DAVID GREEN

WRITTEN REPRESENTATION

HIGHWAYS ENGLAND'S RESPONSE

Drawing title ENVIRONMENTAL MASTERPLAN  
REGULATION 4(2)(e)  
SHEET 4 OF 61  
BURGHFIELD ROAD

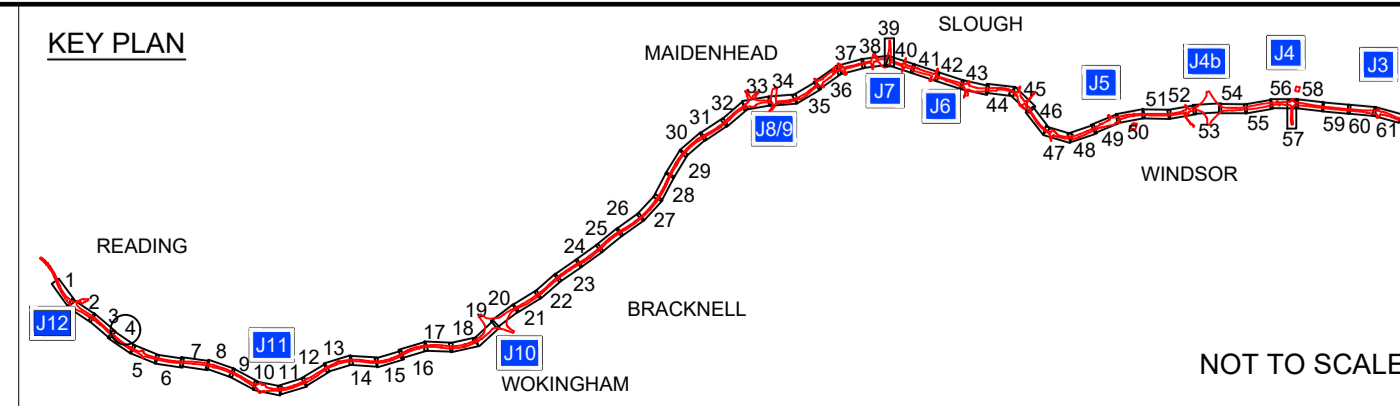
- 1.12 *The fact remains, and was observed during recent site visits, that local residents already suffer from what can be best described as totally unreasonable noise intrusion from the M4. The scheme, as proposed, will do little, if anything, to change this and even the status quo suggested by HE does not stand up to objective scrutiny. I remain of the view that a major, strategically important infrastructure scheme designed in Britain today, and costing around £0.8Bn, should be properly engineered to mitigate extensive traffic noise rather than merely attempting to accommodate future traffic demand.*

- 1.12.1 Highways England does not agree with the terminology used by Mr Green regarding the noise conditions to the Lower Earley area, but accepts that the noise levels are elevated as a result of the motorway. As detailed in response to paragraph 1.10 above, additional noise mitigation to Lower Earley has been considered as part of an enhanced noise mitigation study, which comprises the provision of a significant number of additional noise barriers and the replacement of a significant number of existing noise barriers with higher noise barriers.

- 1.12.2 The results of the enhanced noise mitigation study are provided with the submission at Deadline V. The confirmed barrier provision is detailed within Appendix E of the Enhanced Noise Mitigation Study Report (Ref 514451-MUH-00-ZZ-RP-EN-400158). Sheet 4 is relevant to the Lower Earley area.

- 1.12.3 The results of the enhanced noise mitigation study show that an additional 2126 metres of 2.5 metre high noise barrier will now be provided at this location. The provision of this mitigation will provide further noise decreases to properties in Lower Earley, in addition to those presented in Sheet 4 of Drawing 12.4 of the ES (which showed minor noise decreases across Lower Earley on Scheme opening, without enhanced mitigation).
